RE: Sunport Cell Phone Parking Lot

2200 Sunport Blvd. SE Grading & Drainage Plans

Engineer's Stamp Date: 1/25/2023 Hydrology File: M16D024C

RE: TR A-1 Plat of TRS A-1 & A-2 Sunport Municipal Addn. (M16D024C) 2200 Sunport Blvd. SE **Grading and Drainage Plan Engineers Stamp Date 8/26/2022**

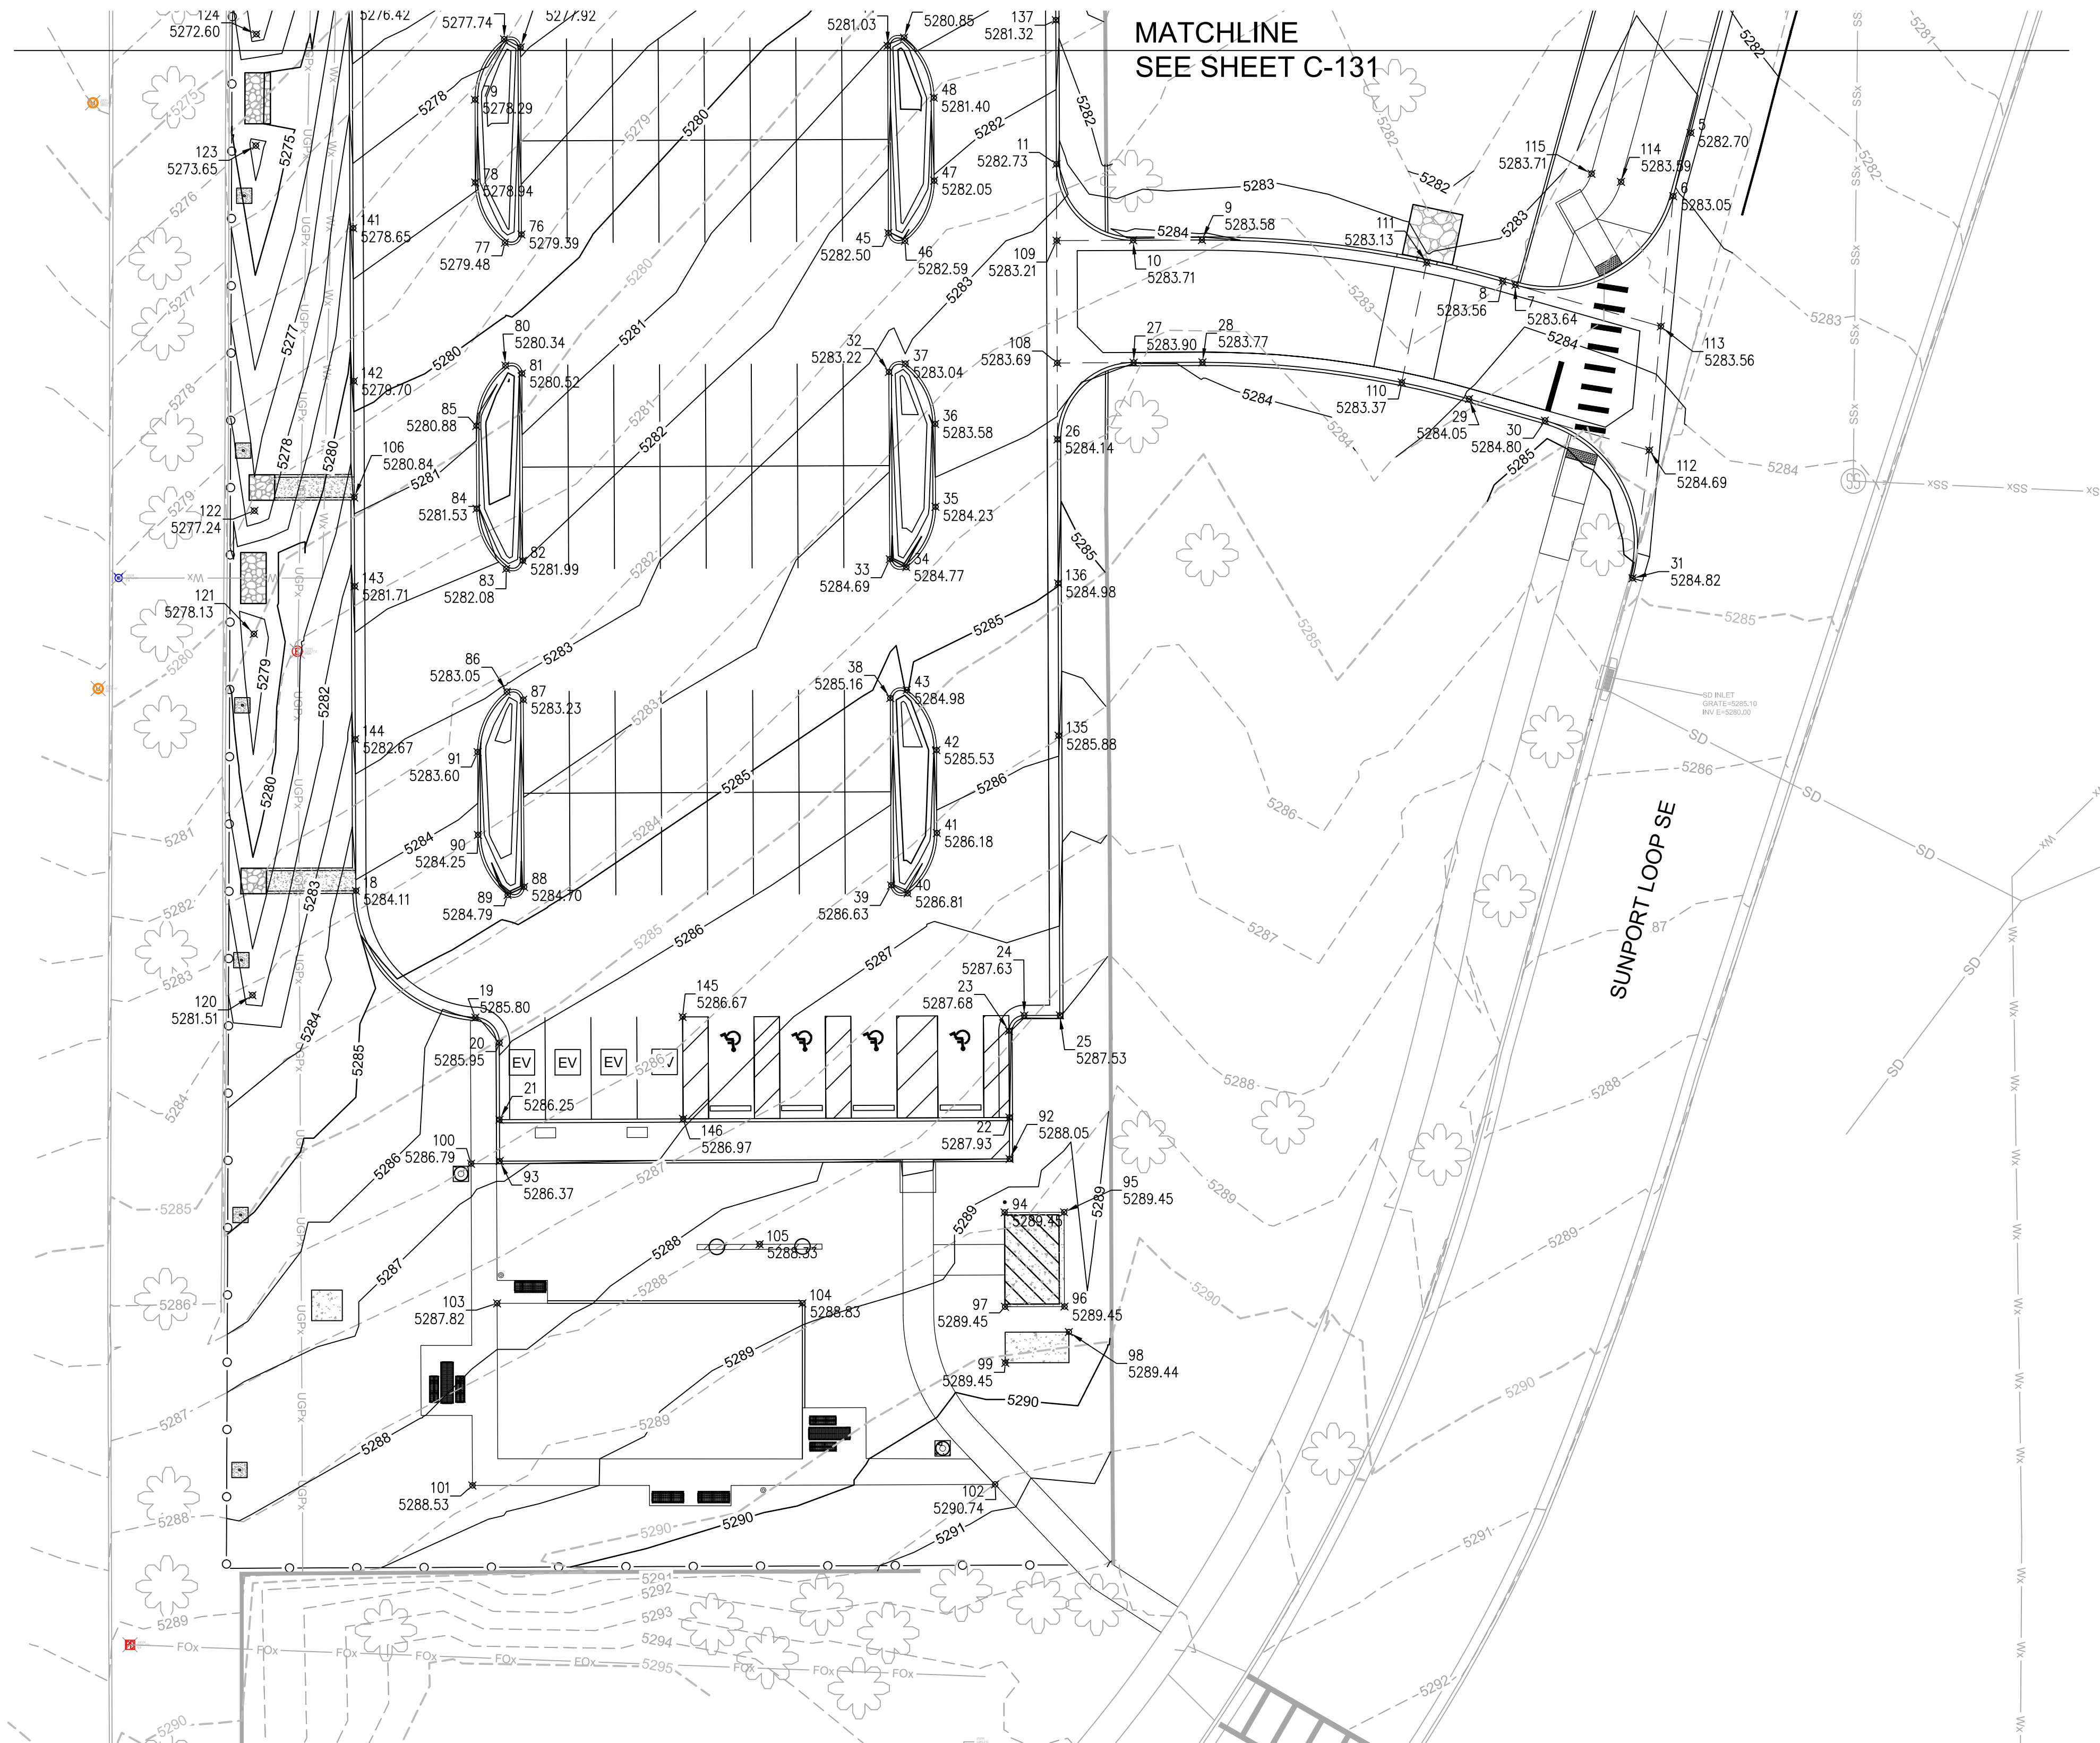
- B. Picture of existing site condition provided on sheet C-141. Please provide more information about the existing inlet and provide inlet capacity calculations. Show spot elevations around the inlet to ensure runoff will not drain to the north instead of draining to the inlet. Please include a note that existing inlet to be cleaned (most likely full of sediment). Concur. Additional information and capacity calculations has been provided on sheet C-130 & C-142.

- 7) Was a Traffic Circulation layout submitted to Transportation for review and approvals? Acknowledge, Transportation is currently under review.
- 8) Provide Finished Floor elevation for the restroom pad.
 Not Concur, Finished Floor elevation for the restroom pad has provided on sheet
 If you have any questions, please contact me at 924-3999.

C-130 Grading Plan.

City Project No. 6564.00-T4 Zone Map No. M-16 Drawing No. C-141 Sheet Of

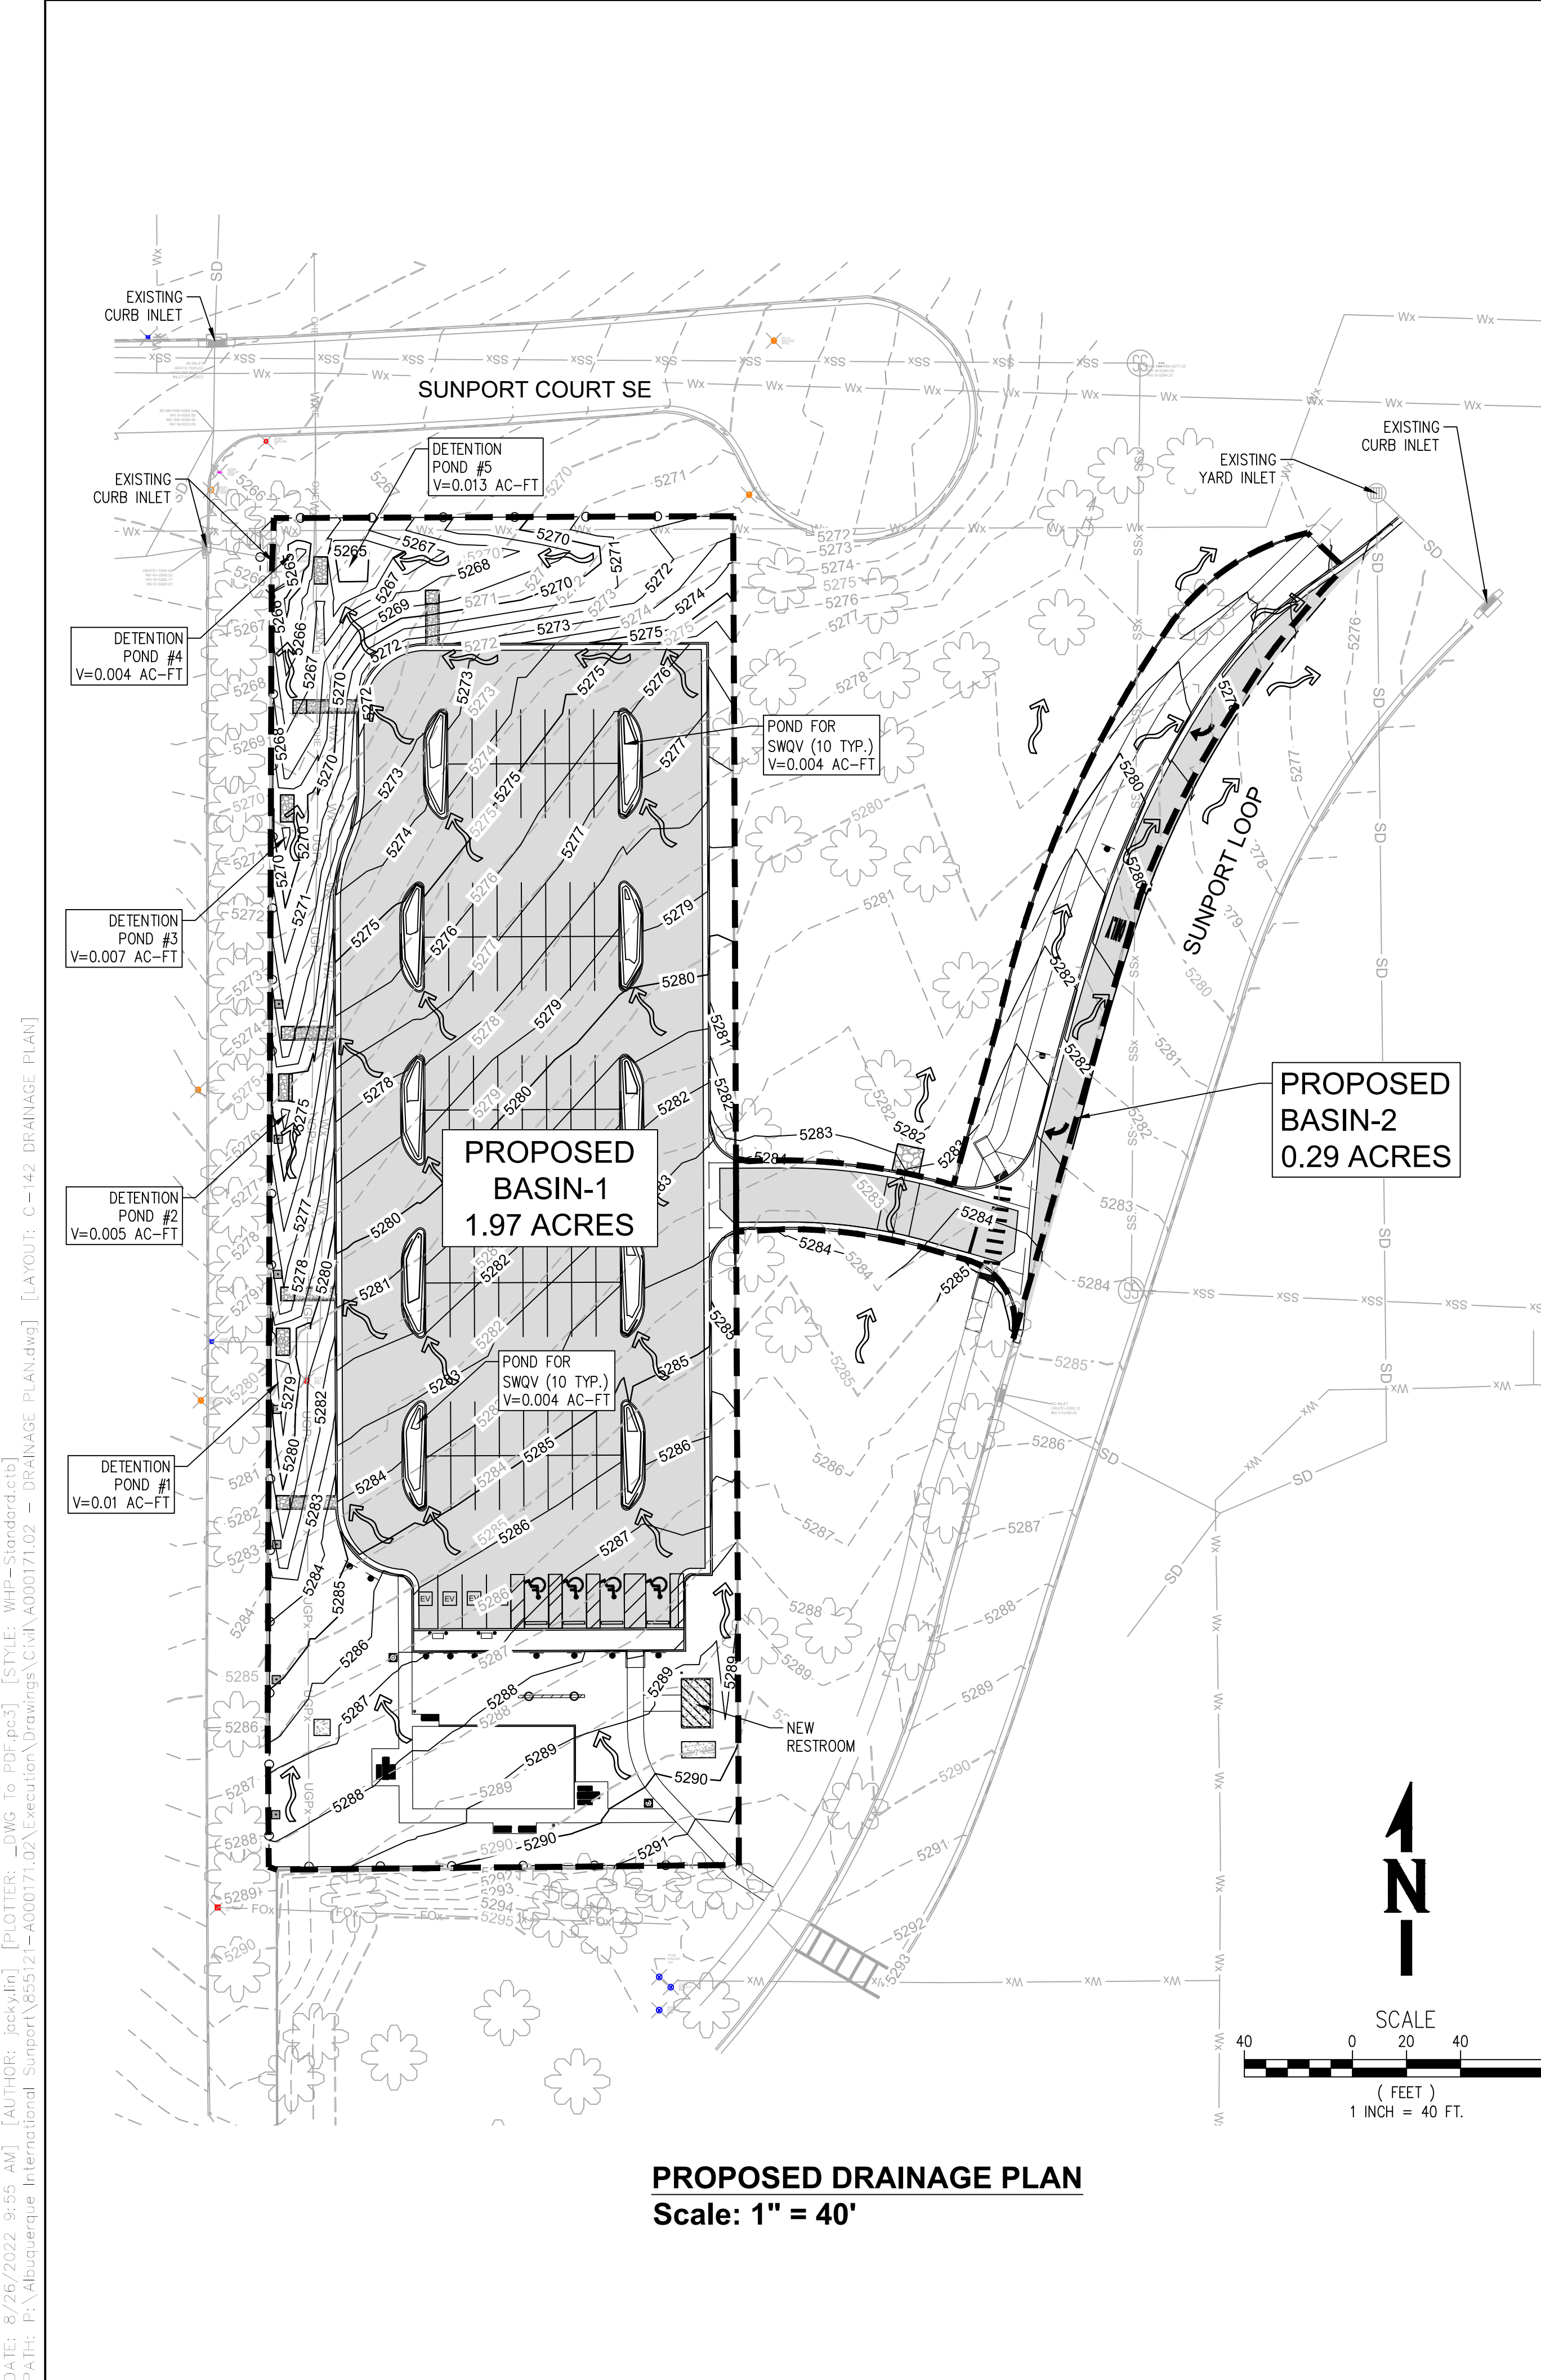
- 4) Please double check the treatment used in your runoff calculations both under the existing and proposed conditions. Under existing conditions, the treatment C is at 70%. It appears that the site is about 50% B. under the proposed conditions percentage D might be higher than show. Treatment used has checked, treatment C is at 70%, site for Ex. Basin 1 not considered treatment.

- 6) First Flush Volume (using storm water quality pond/retention pond) must be provided per the DPM. Detention ponds as mentioned on the plan does not address the First Flush Volume requirements.

Not Concur. The first flush volume was computed, see calculation on sheet C-142 Drainage Plan, first flush volume was captured within the proposed detention ponds and landscape islands.
